## **RESPONSE TO SUBMISSIONS - SECTION 4.55(2) MODIFICATION APPLICATION CROWN SYDNEY HOTEL RESORT**

This submission has been prepared on behalf of the applicant, Crown Sydney Property Pty Ltd, in response to submissions received in relation to S4.55(2) Modification Application relating to the approved Crown Sydney Hotel Resort Development Consent SSD 6957 located at 51a Hickson Road, Barangaroo, NSW (**Development Consent**).

8.3 ACCESS TO SUNLIGHT

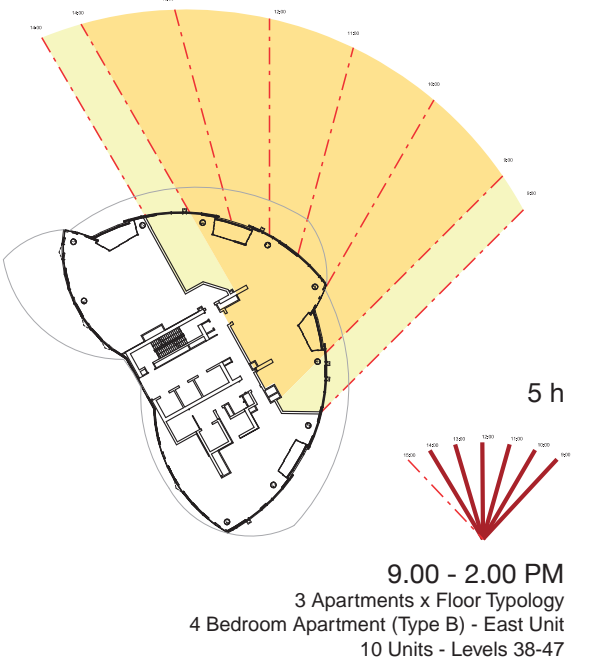
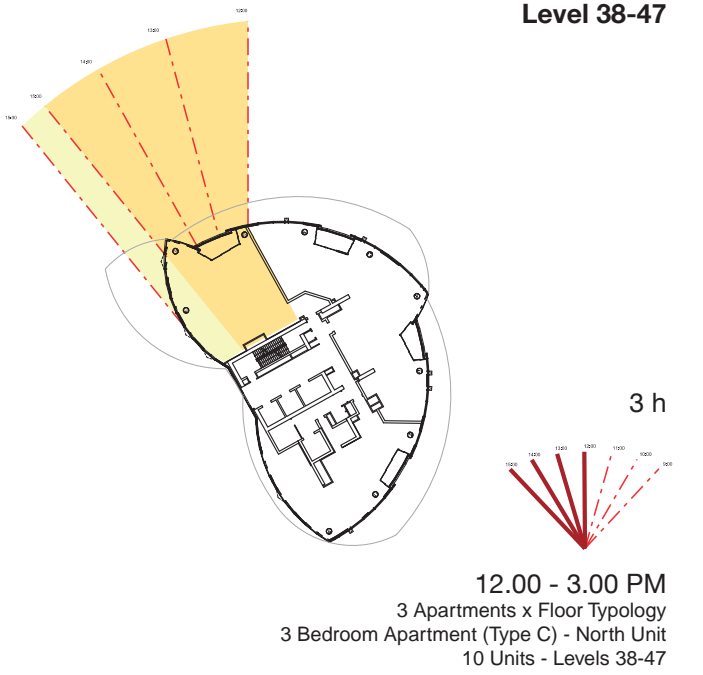
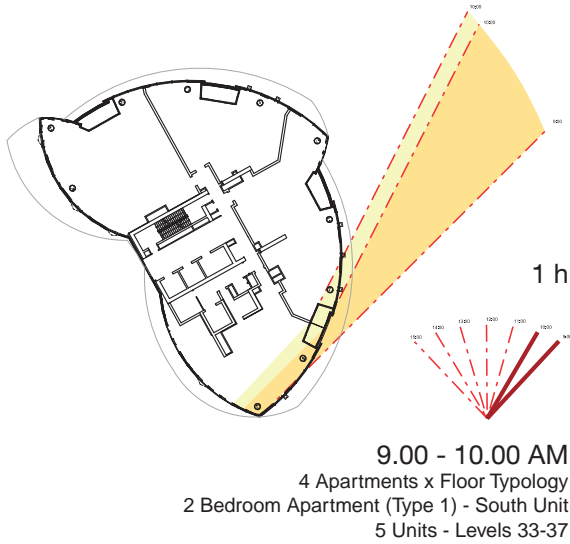
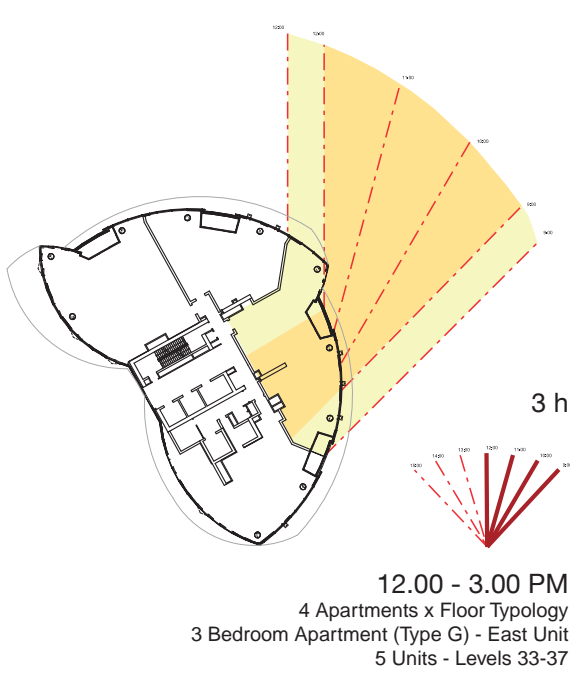
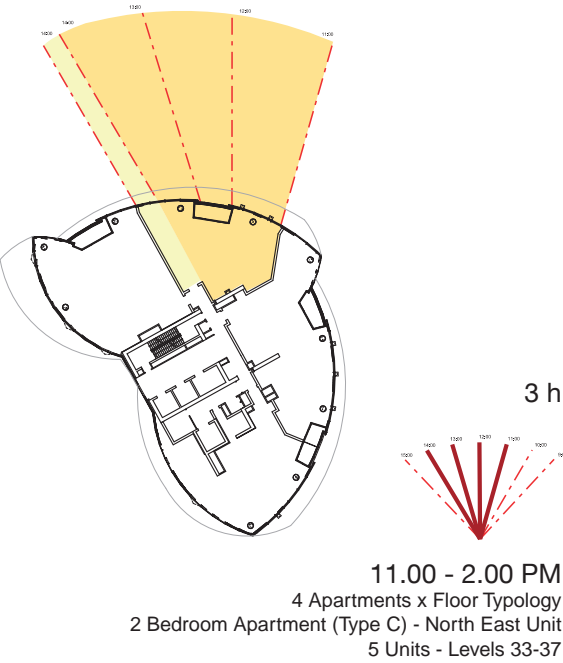
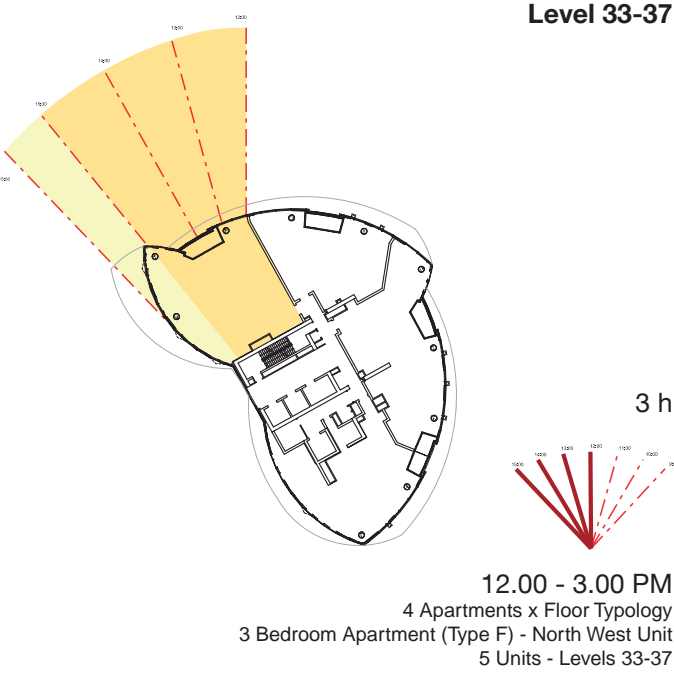
*“Additionally, evidence has not been provided to confirm apartments receive adequate solar access within living areas and on balconies. No such shadow and solar access assessment has been provided for review and compliance cannot be confirmed.”*

In relation to the Council's comments relating to solar access, we note that the Design Verification Statement prepared by Bates Smart confirms that the proposed modification is compliant with the required solar access controls and design guidance solutions. Further to this, the solar access study prepared by executive architect Wilkinson Eyre confirms that 73.56% of apartments receive sunlight to habitable rooms, primary windows and private open space, for 2 hours between 9am and 3pm at mid-Winter (See **Attachment D**). This is above the 70% design criteria under Part4A-1 of the *SEPP65 Apartment Design Guide*. The proposed modification is therefore compliant with the required solar access controls.
